**Essex County Council (ECC) - Written summaries of
Oral submissions made at Issue Specific Hearing (ISH) 1 and 2 (2 April to 8 April 2025)**

ISH 1 (2 April 2025 to 4 April 2025)

Visualisation showing cumulative development, including year 1 planting - (90 degree view)

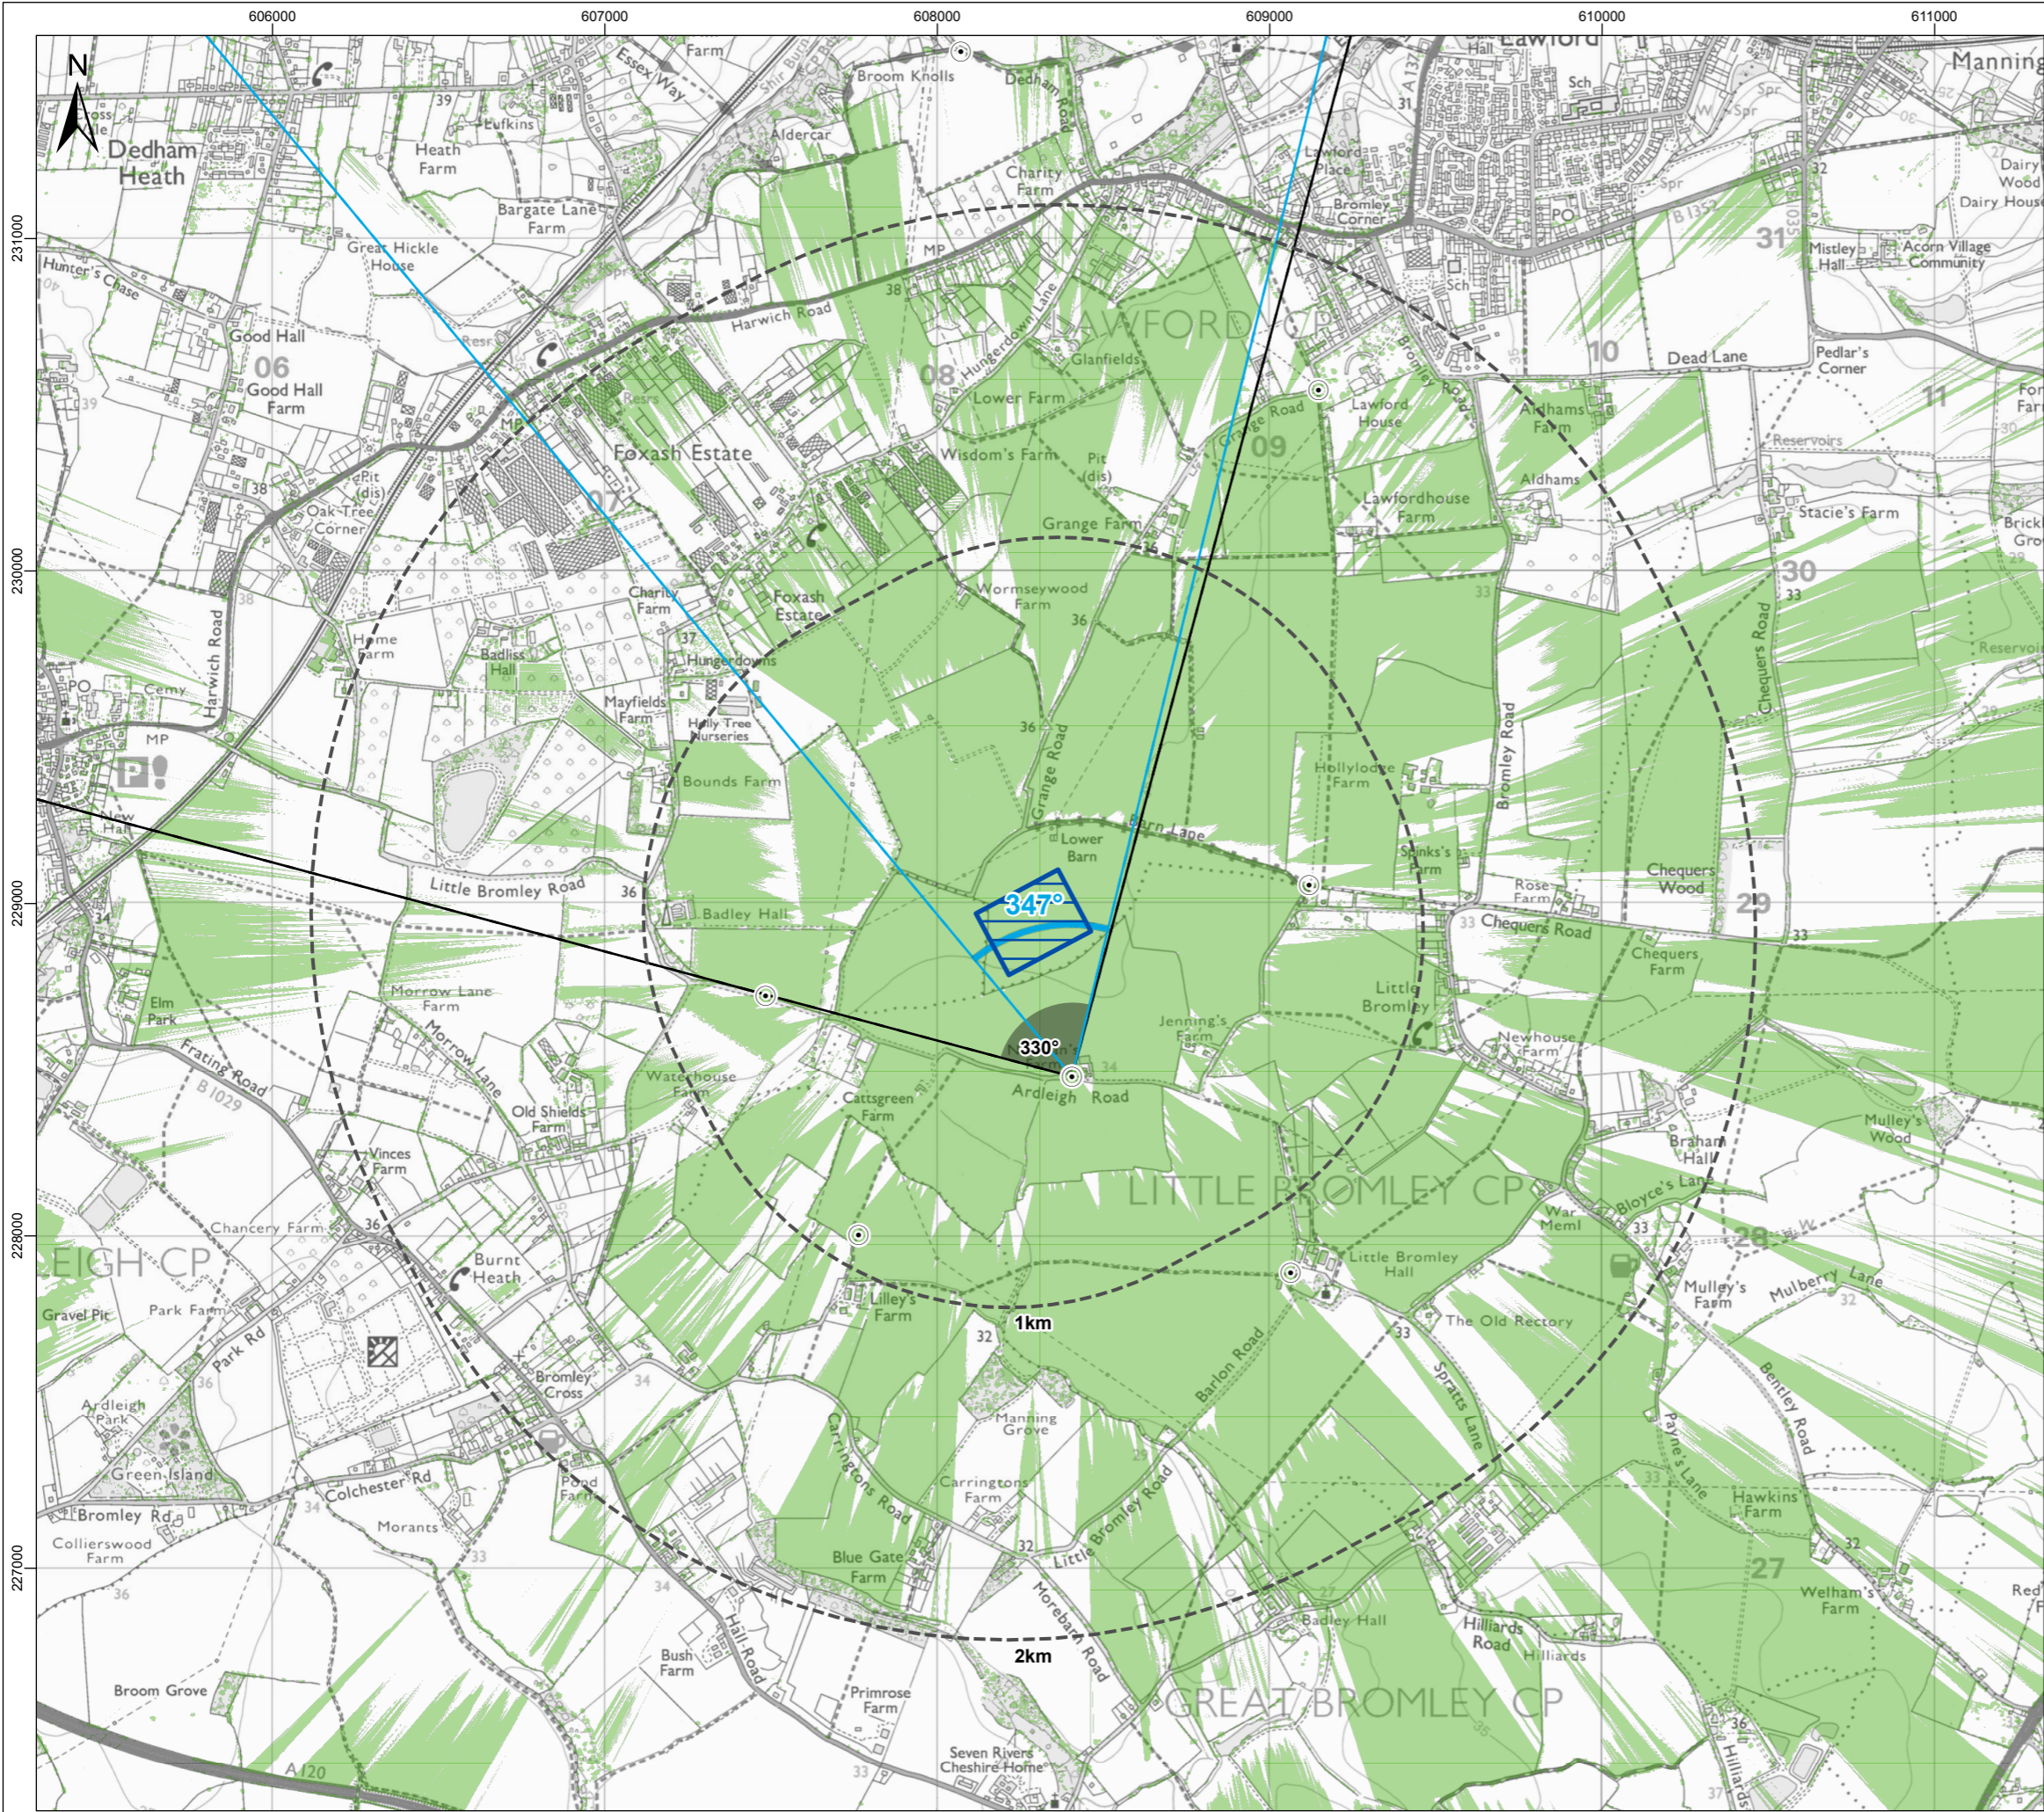
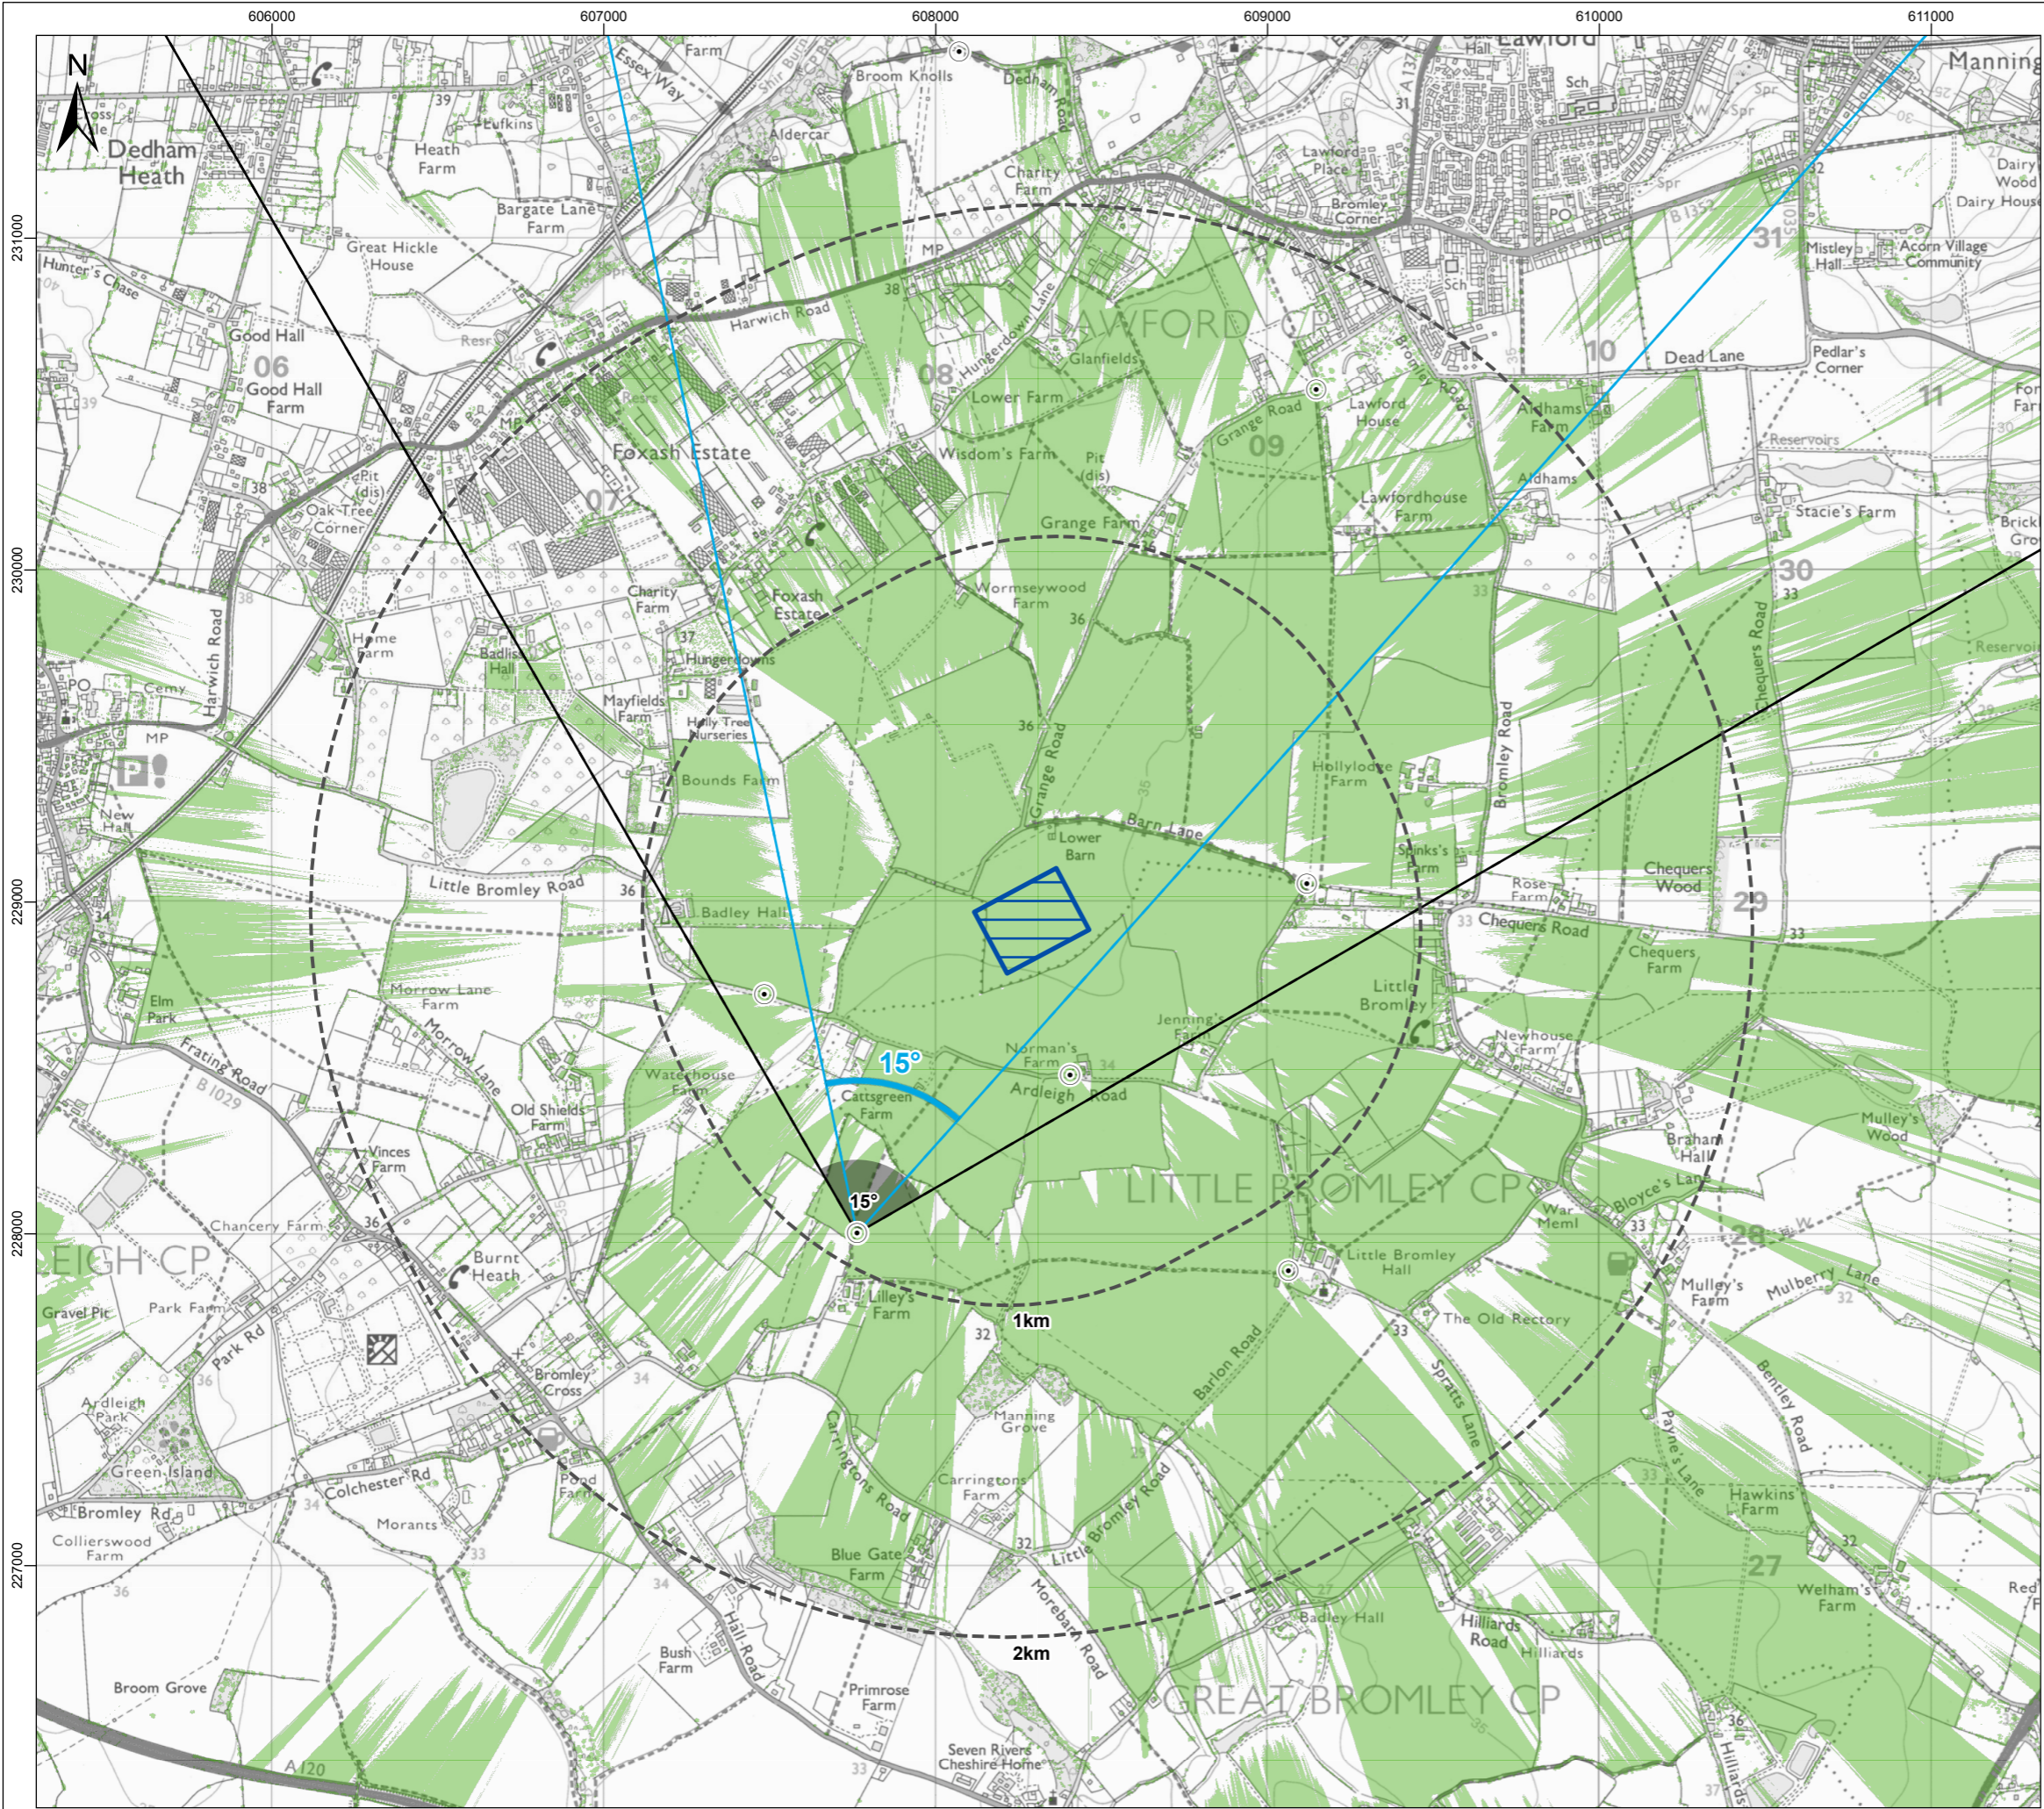
The Council's position is that the extent of the viewpoints is very limited. There are particular places where the applicant could have done more to demonstrate what the impacts are. These include having a series of viewpoints along the Public Rights of Way to the northern boundary of the site. It is also unclear why there are no viewpoints to the northwest of the site, from Grange Road in particular, which for the section that runs alongside the application site, is actually pretty much a country lane in character. Elevation of the substation is the one that can be least mitigated with the planting, because that is the elevation from which the overhead lines will be connecting. It is limited in the amount of planting that can happen along that elevation, so it is important to see what the effects potential are from that direction.

As the applicant has identified that there are residual impacts even though they proposed that the visual ones are not significant. There is that perceptual element to landscape assessment. It is about how people feel as much as what they actually see, which is an important element. So the fact there are going to be residual glimpses of the substation infrastructure above the tree line, it creates a feeling of unease and a perception of the landscape of having been industrialised in relation to landscape impacts.
